**KIRKLEES METROPOLITAN COUNCIL
INVESTMENT & REGENERATION SERVICE**

Reference No: 2019/62/93637/W

Site Address: Holmfirth Civic Hall Community Trust, Huddersfield Road, Holmfirth, HD9 3AS

Description: Erection of roof over rear well to create enclosed space, erection of rear fire escape and interior and exterior alterations (within a Conservation Area)

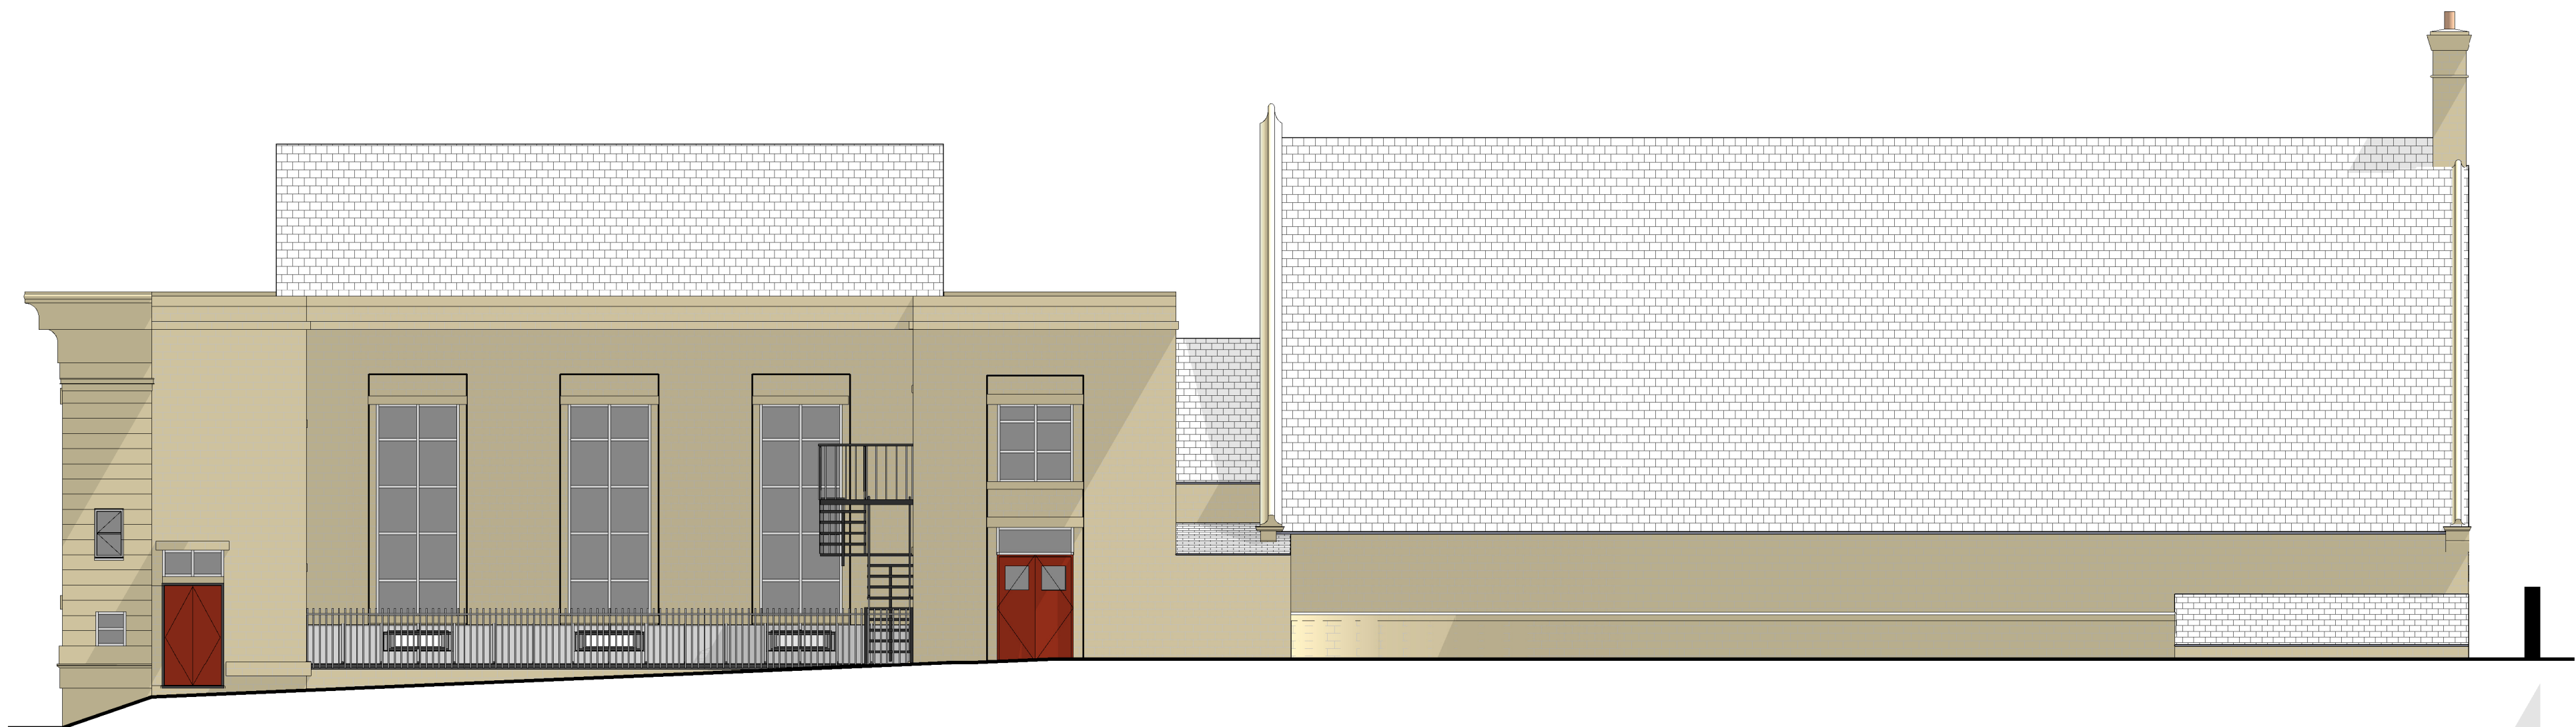
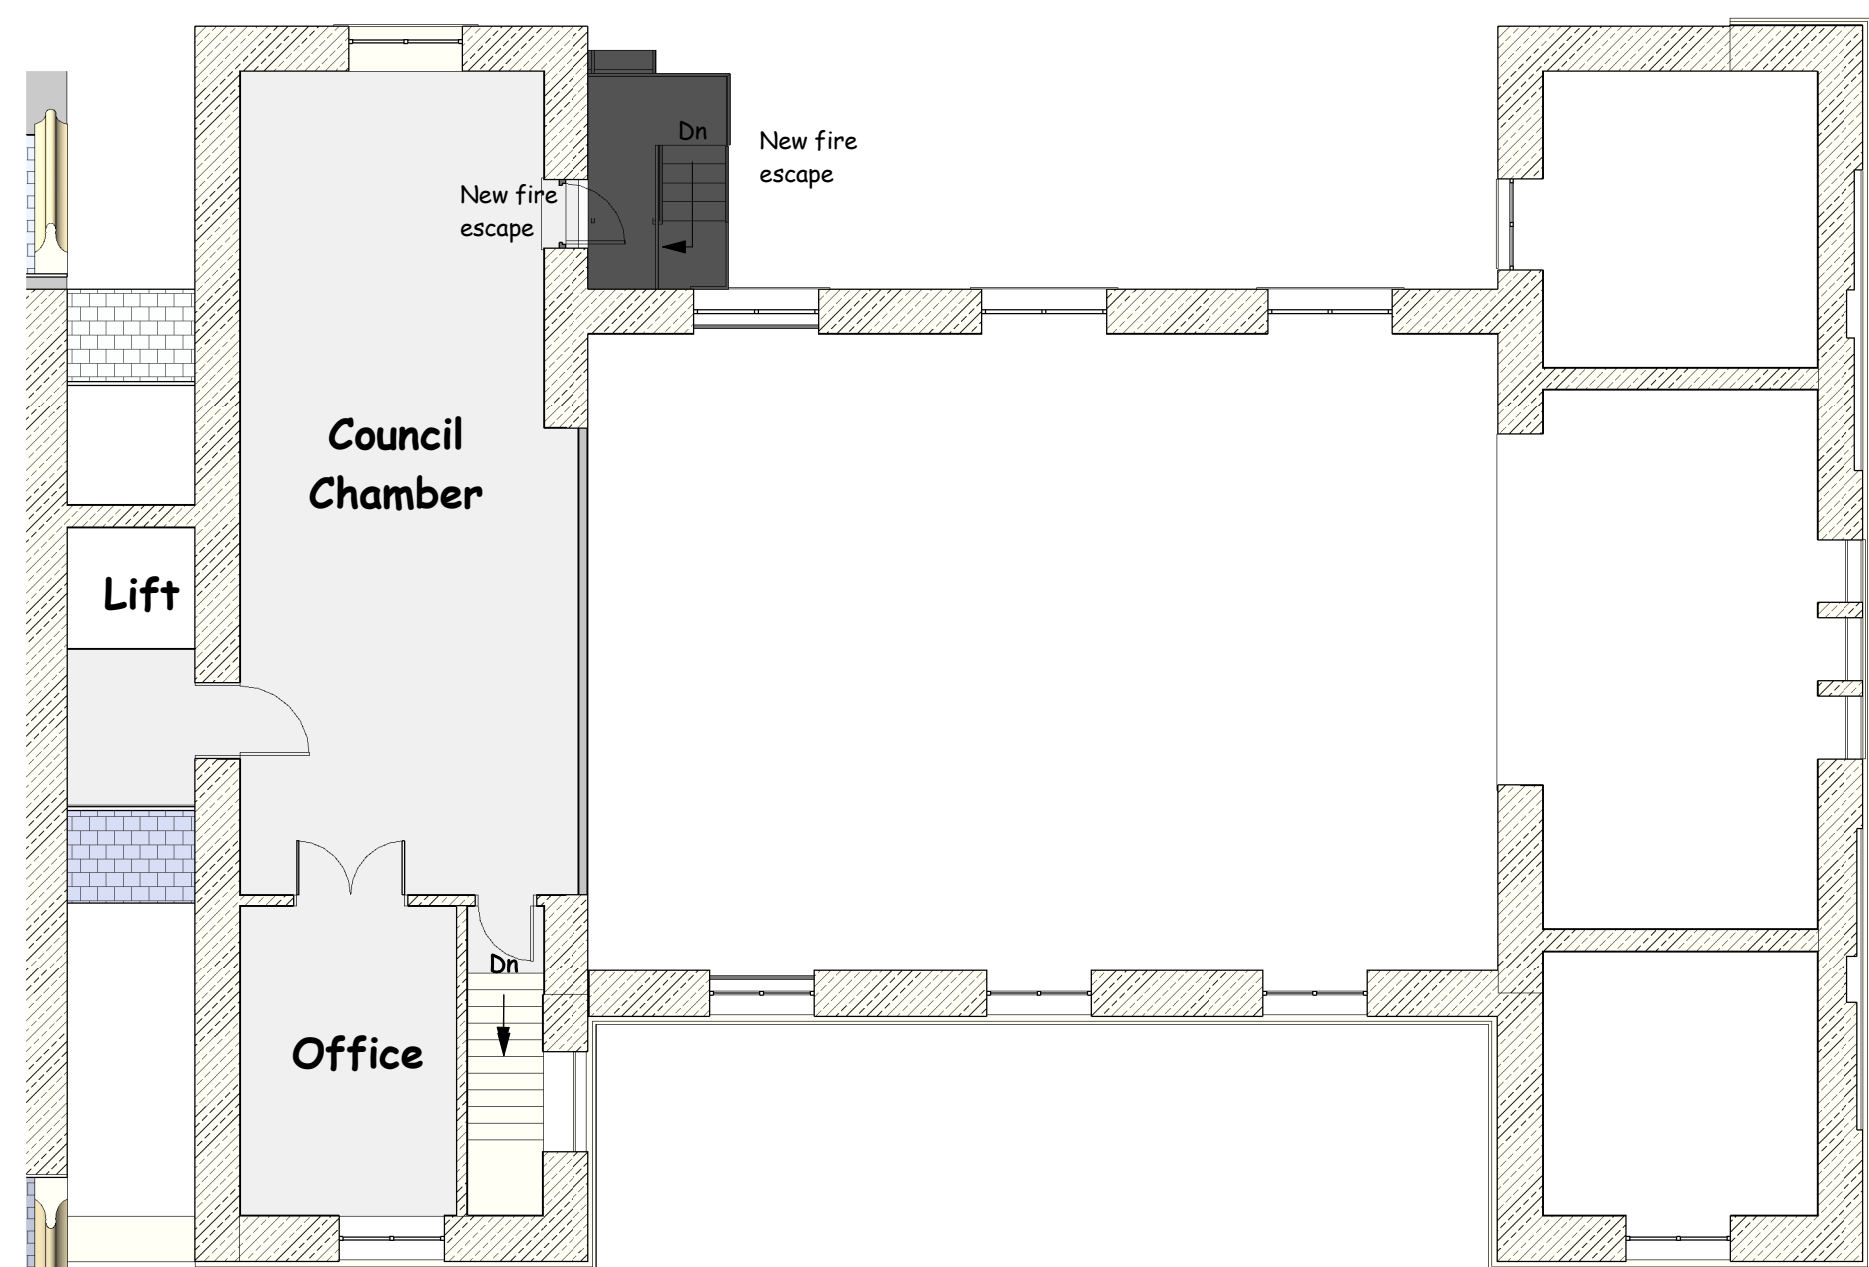
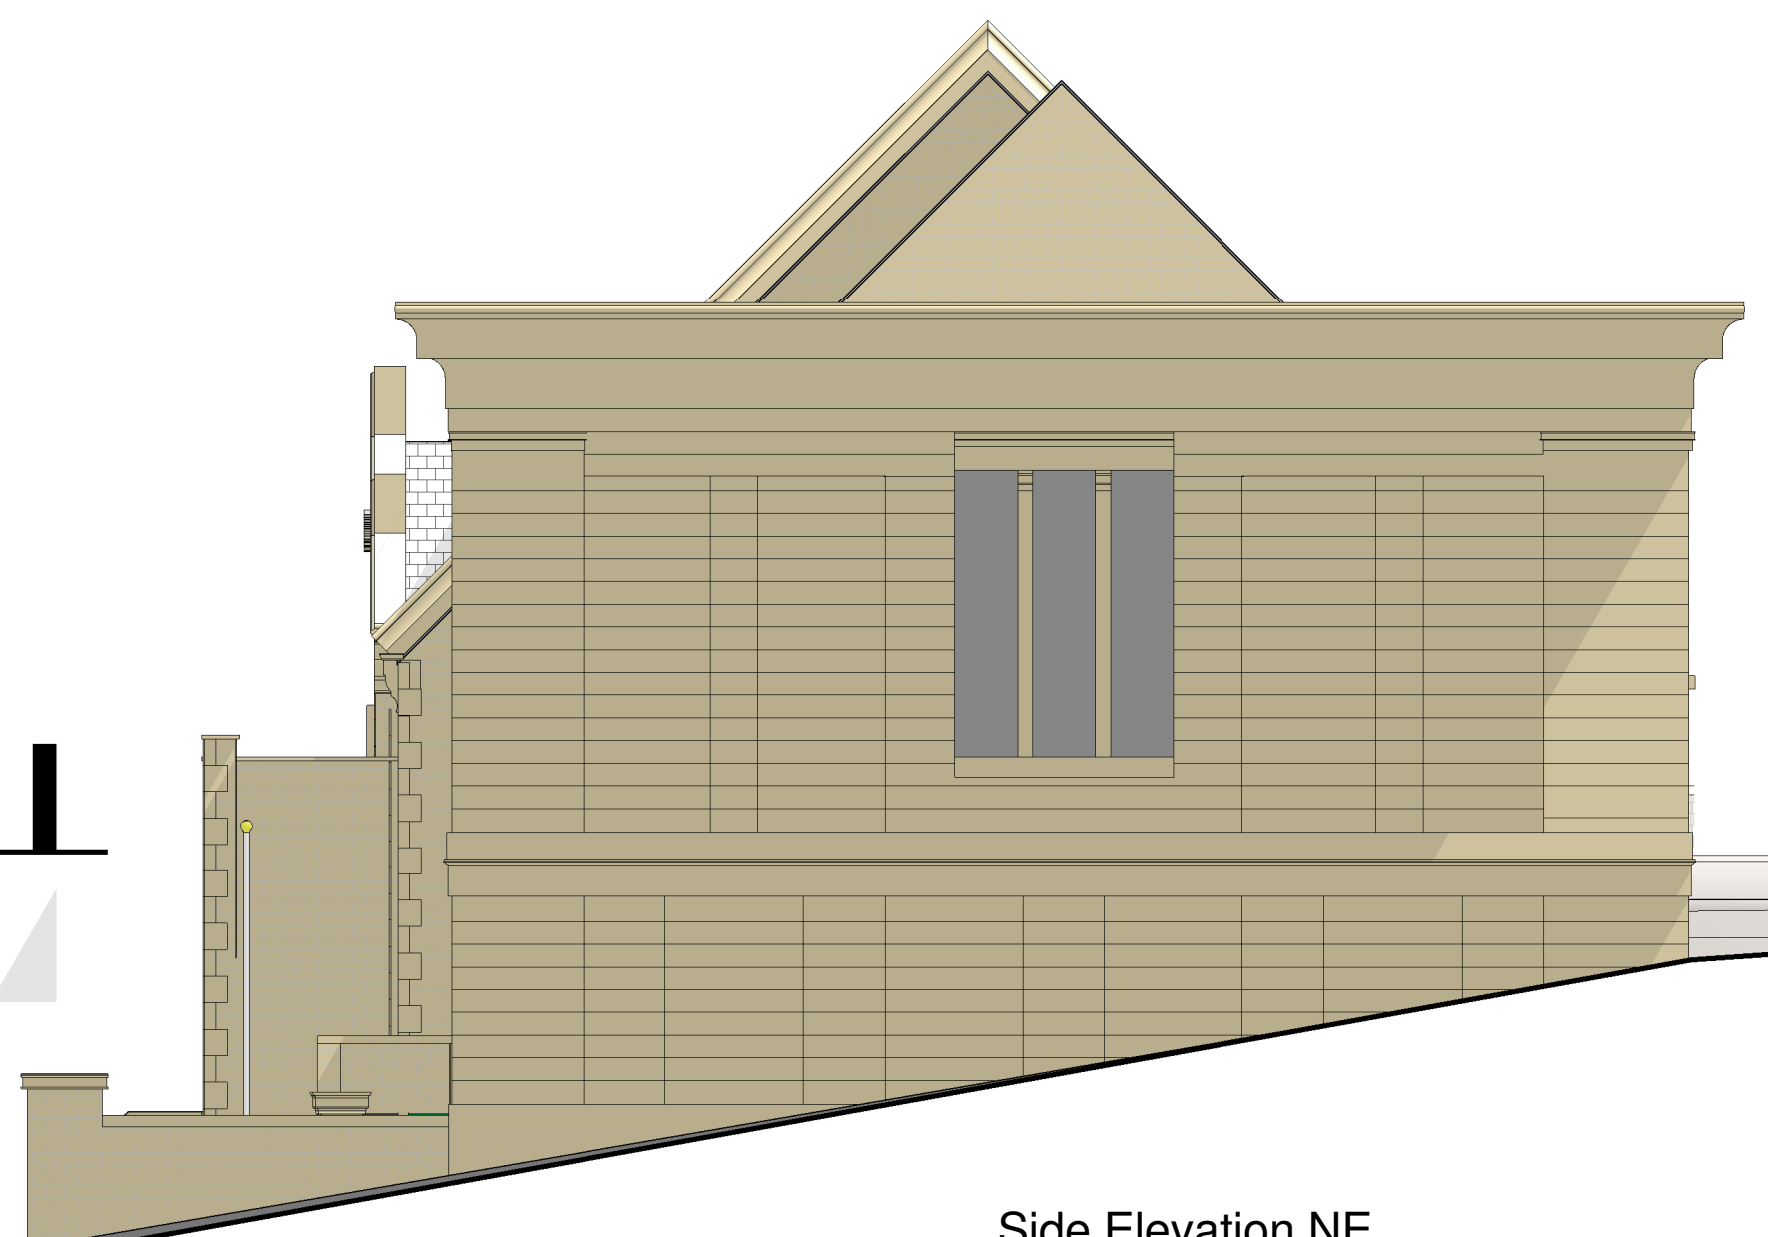
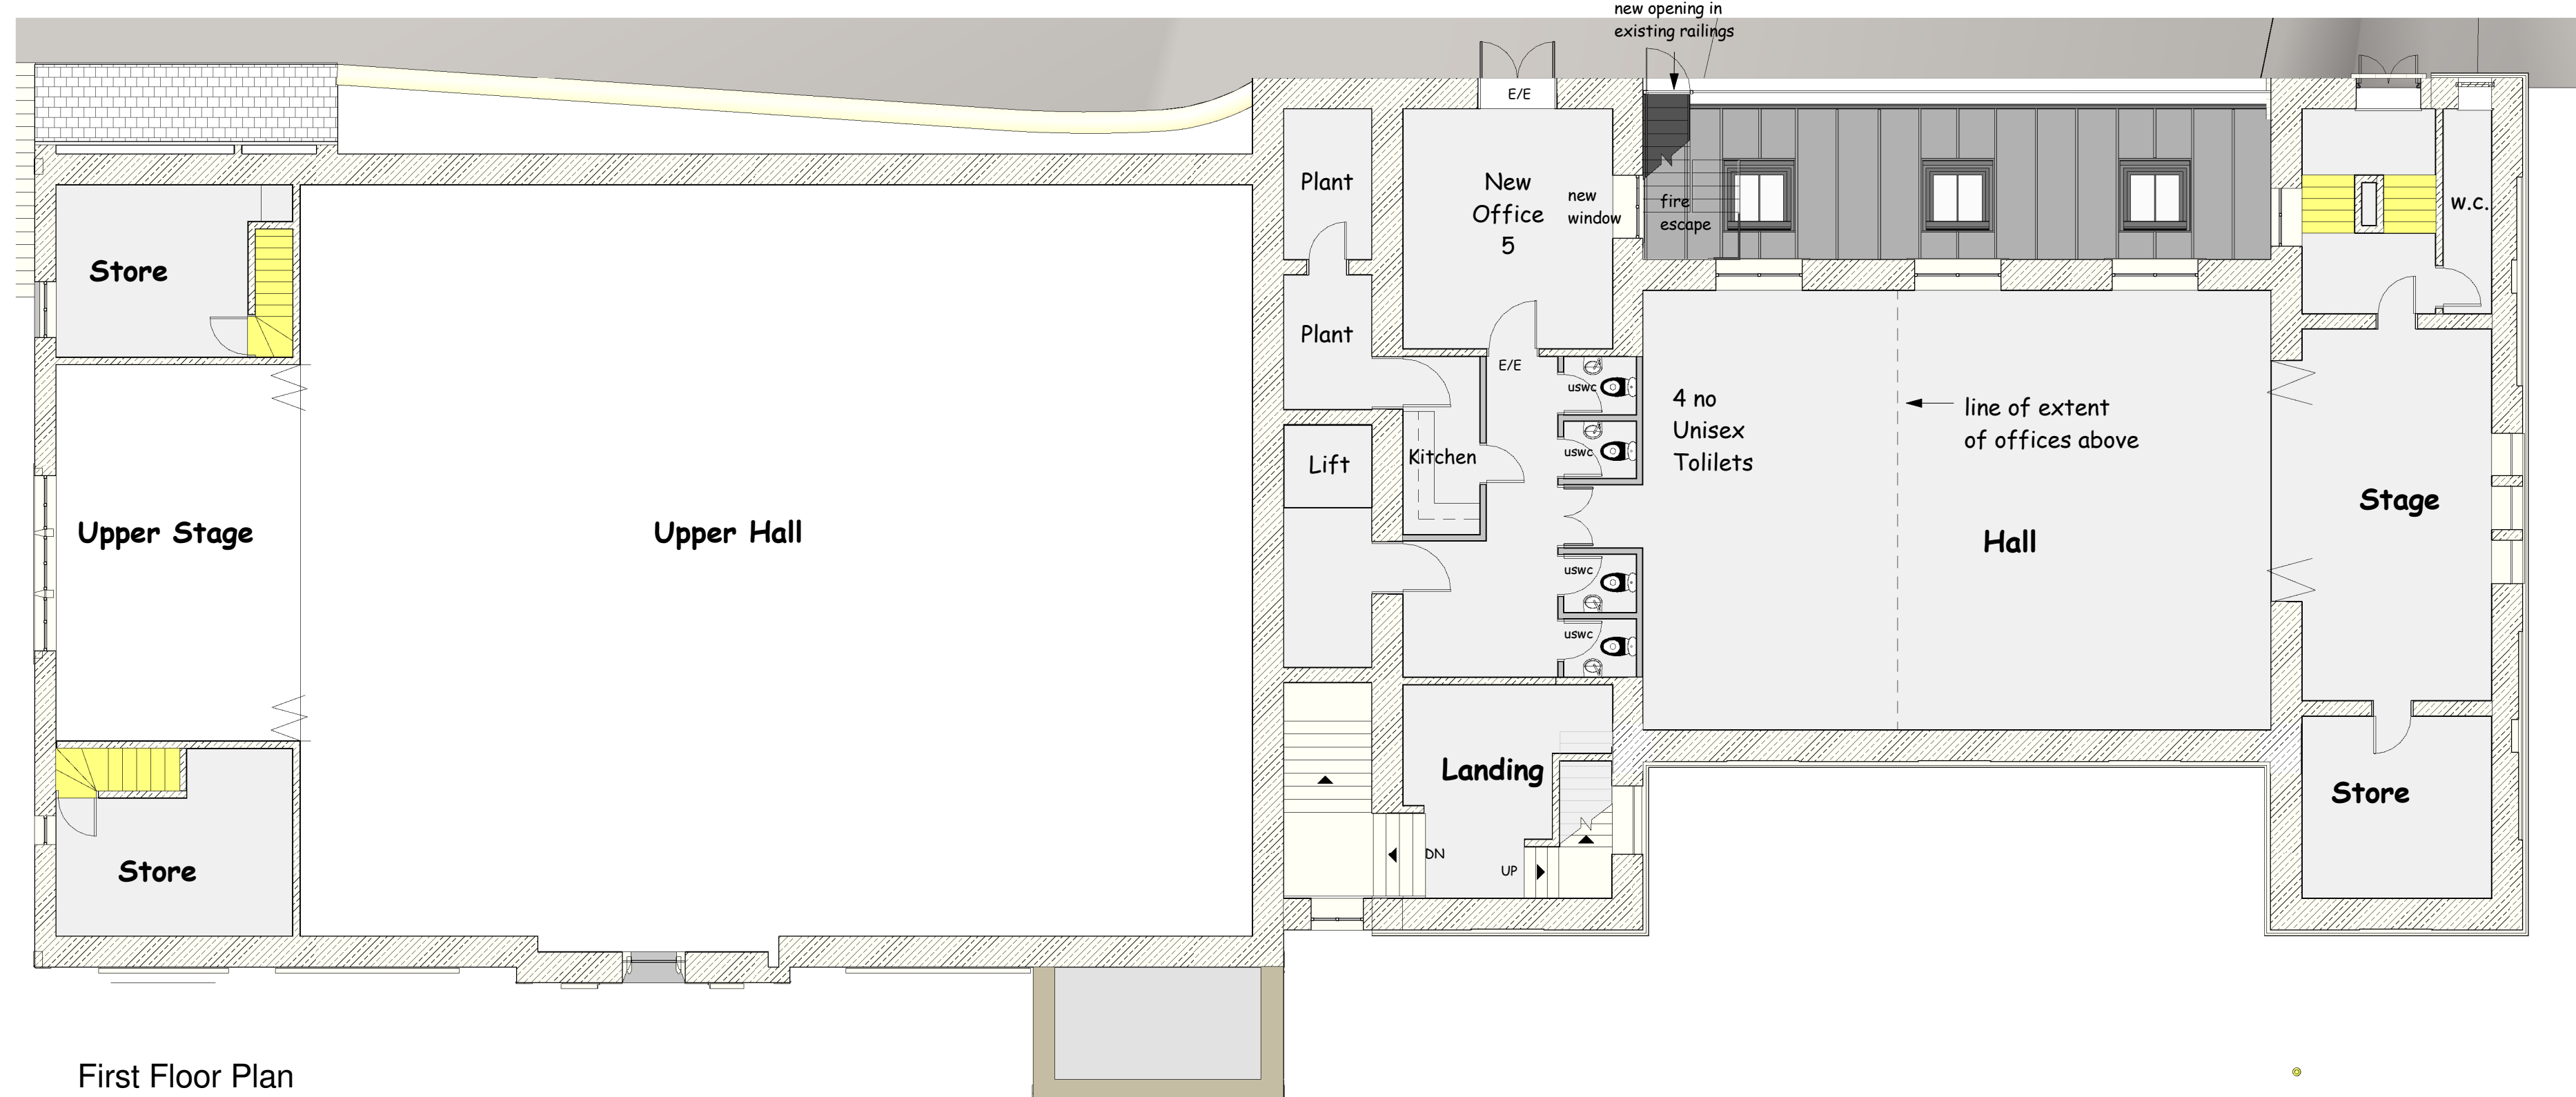
Conservation and Design – concerns were raised in regards to the proposed first floor office window located behind the fire escape and instead a single window inserted adjacent to the existing rear exit door in this room is suggested or alternatively a vertical window on each side door.

character of the building. Further, the erection of a fire escape adjacent to the rear well facilitates an increase in capacity in the first floor meeting room. Whilst the works are fairly obtrusive the staircase is located on the rear of the building in an area of low significance. Whilst there are concerns regarding the siting of the structure in front of an existing window but this is as a consequence of the site constraints. The intervention of a large escape structure will lead to less than substantial harm to the character of the building and, on balance, it is considered that the public benefits in improving safety and enabling a sustainable use for the upper floor space outweighs the harm. Conservation and Design raised concerns about the proposed first floor office window located behind the fire escape and suggested that a single window is inserted adjacent to the existing rear exit door in this room or a vertical window on each side of the door. A revised drawing was submitted showing a modified window in the same position with a design that harmonises well with the overall rear appearance which on balance satisfies Conservation and Designs concerns.
